BCA Assessment Report

ESR Huntingwood – Buildings 1-4
Augusta Street, Huntingwood
SSDA-36138263 – MOD 2 Submission

15 June 2026

1 BUILDING 3 - BASEMENT LEVEL 1 : 750

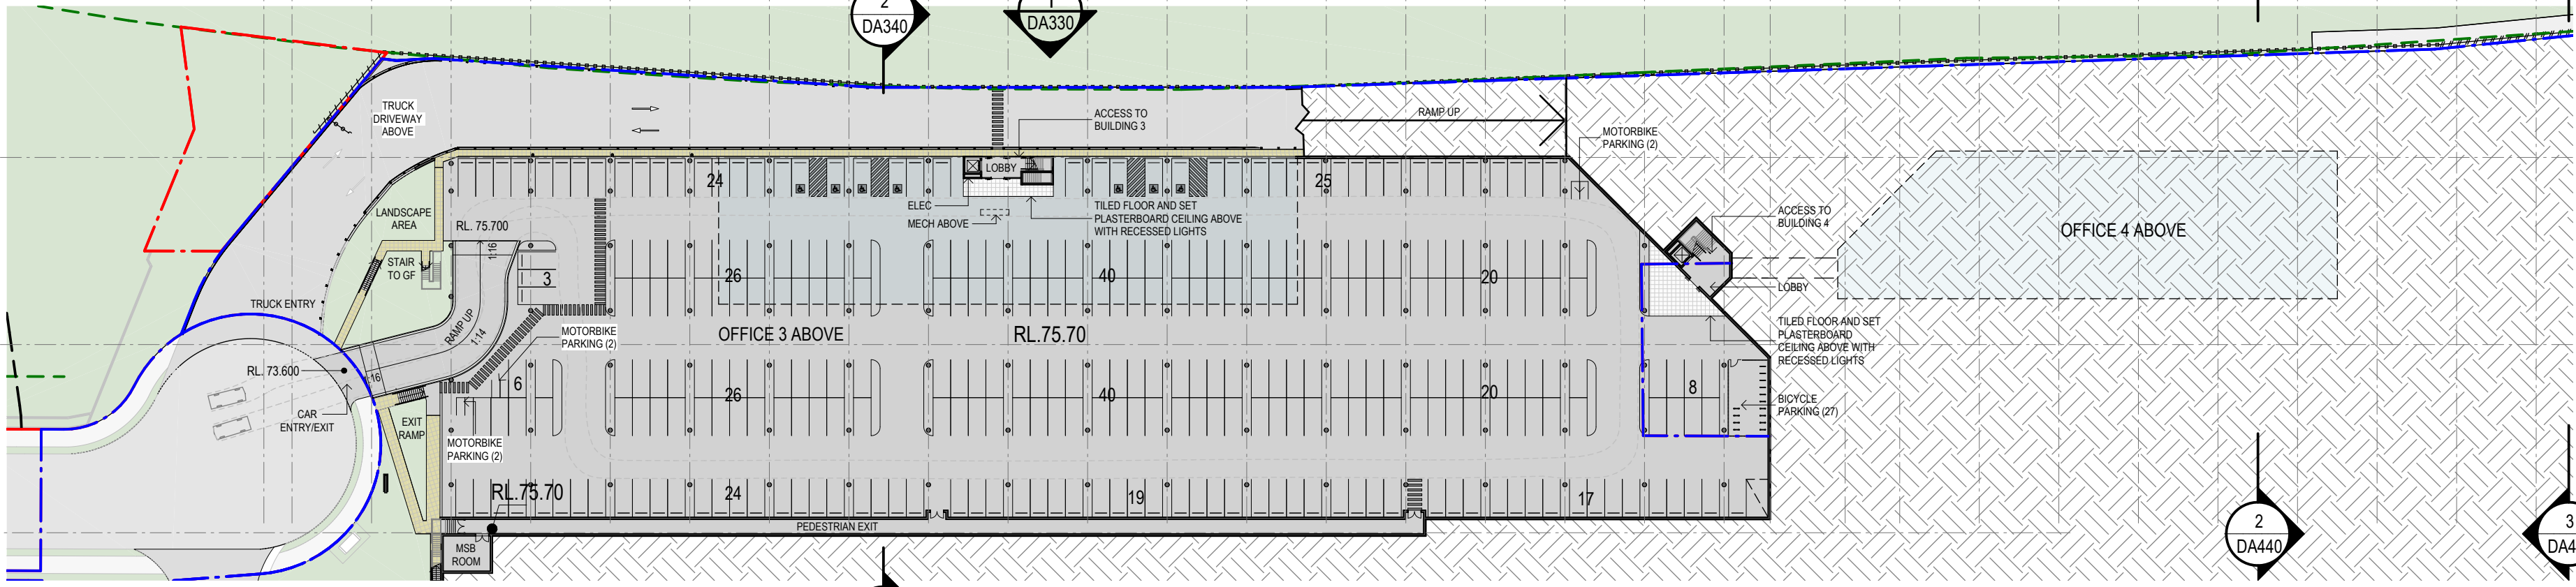
11.	D4D6	There is an excess of 200 parking spaces, however only 2 accessible parking spaces have been nominated on the plans for the Building 3 basement carpark.

1 BUILDING 3 - OFFICE - GROUND FLOOR 1 : 200

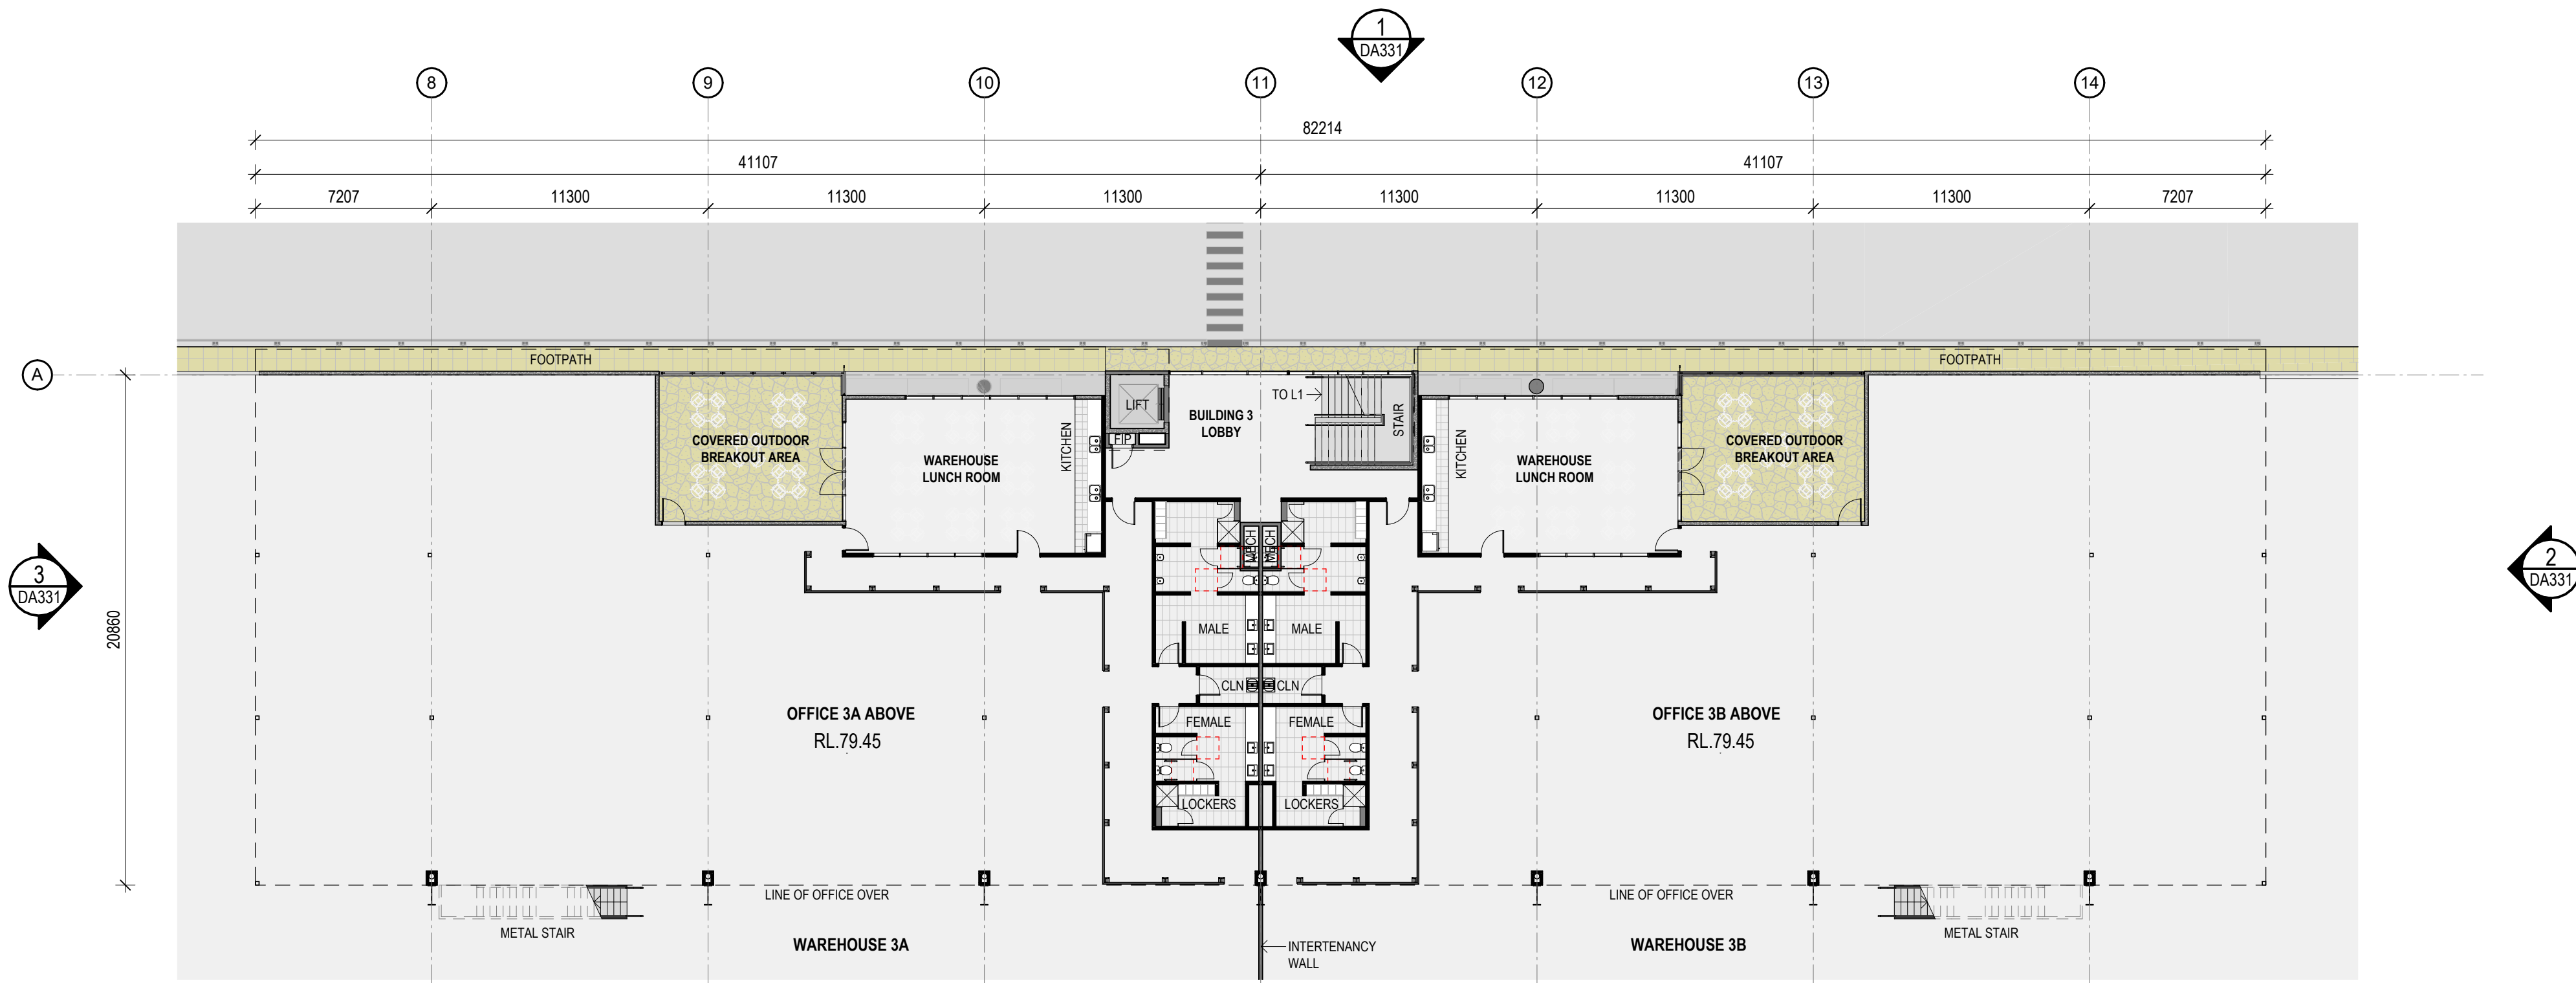
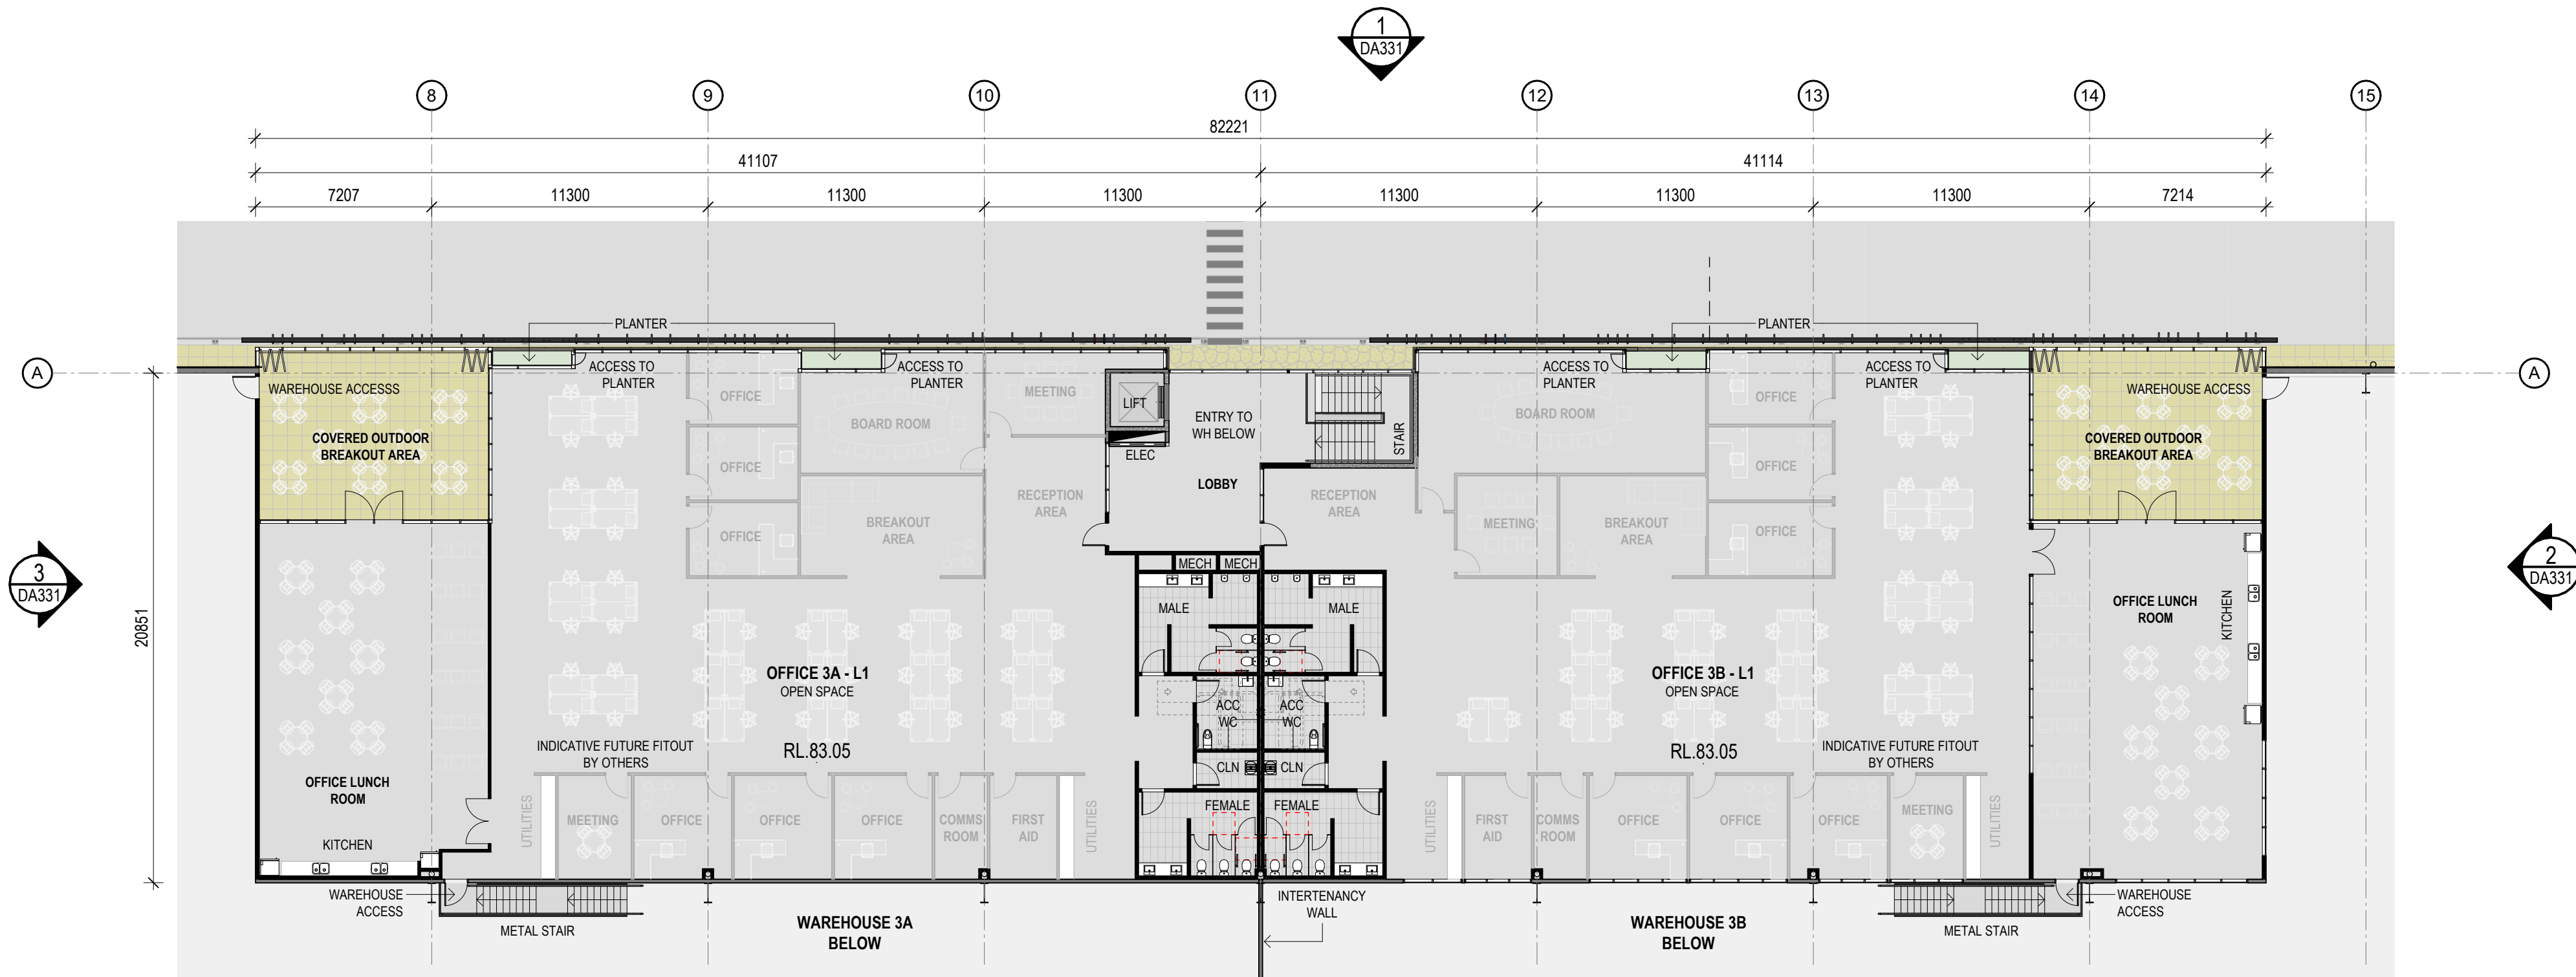
7. D3D9	The cupboard located under the stair is required to have enclosing walls and ceilings achieving an FRL of 60 minutes and the doorway will need to be fitted with a self-closing -/60/30 fire door.

1 BUILDING 3 - NORTH ELEVATION 1 : 500

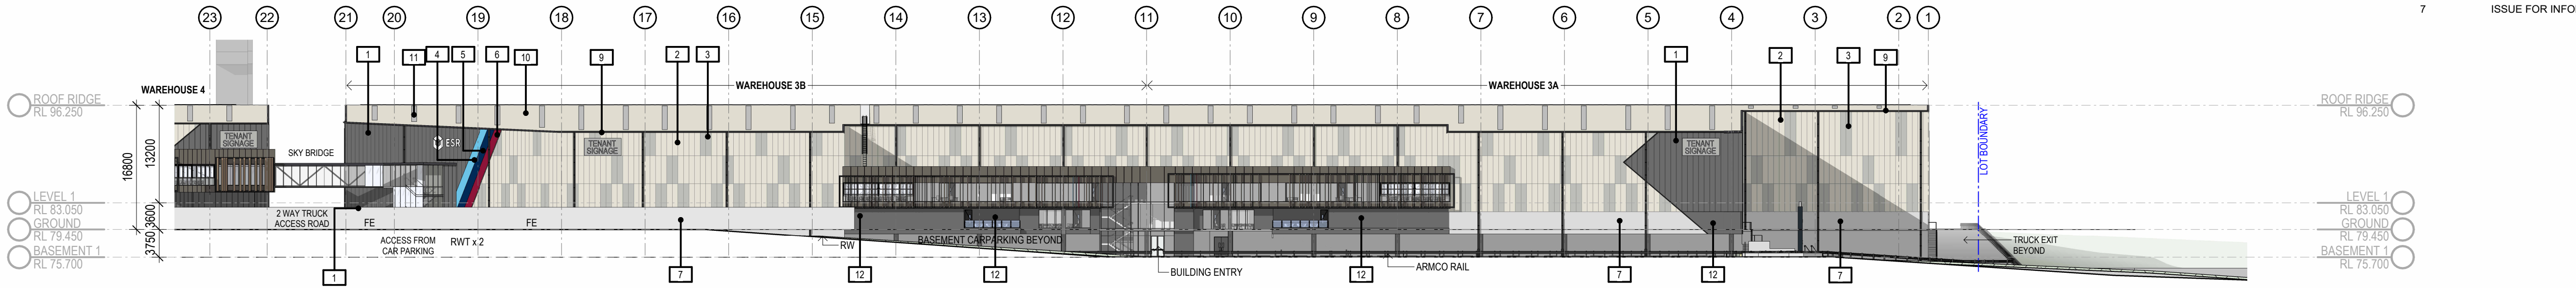
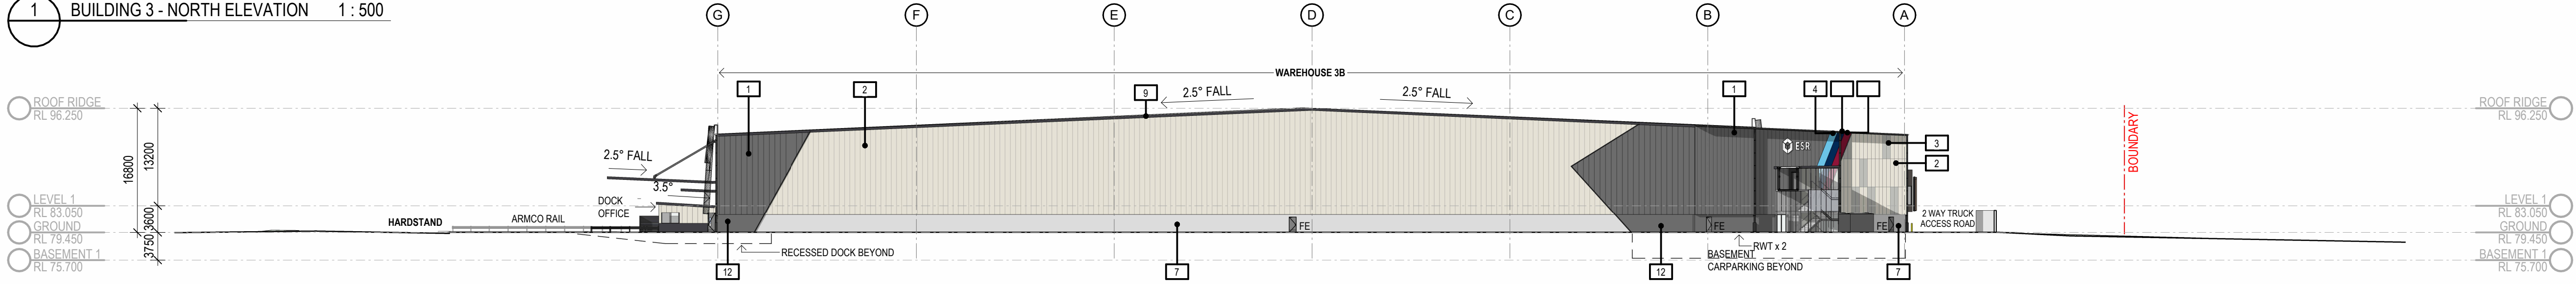
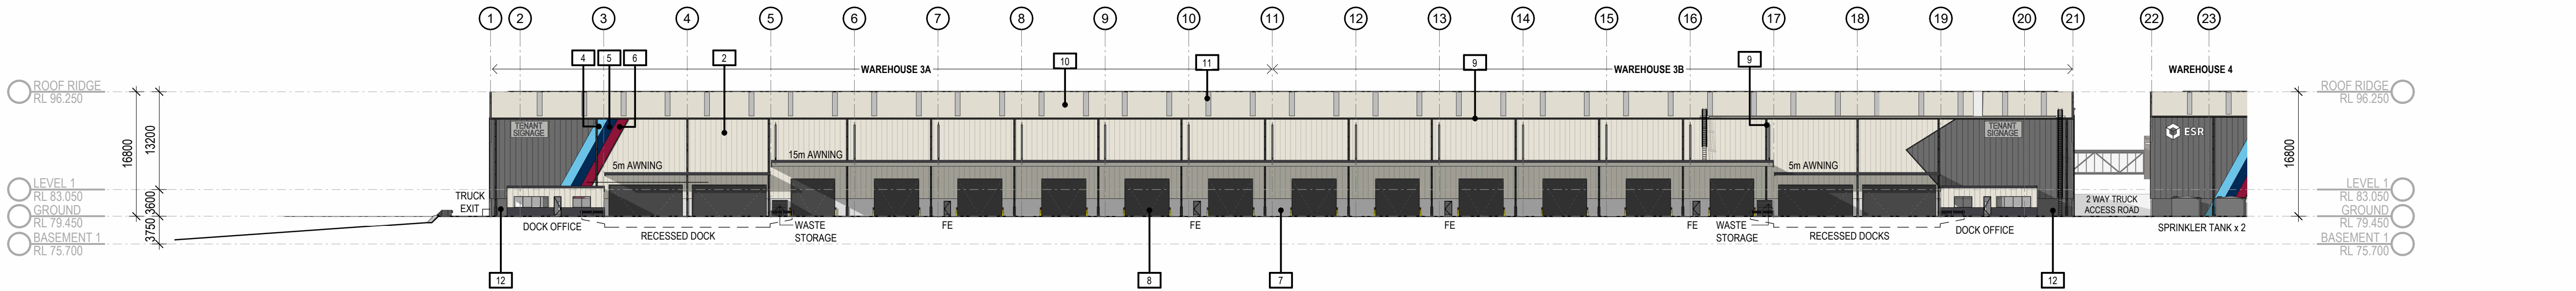
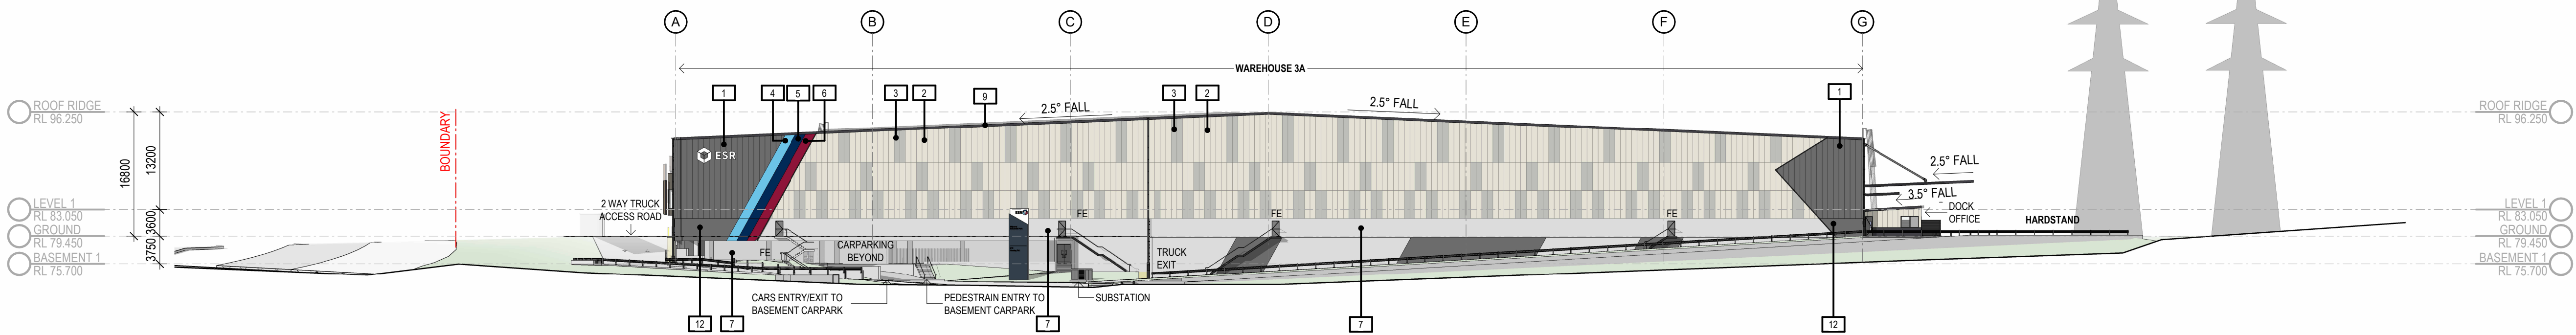
2. C2D10 & C2D14	Details of the non-combustible external walls, including all ancillary elements and attachments, to the Offices and Warehouses of Building 3 are required to be provided for assessment.
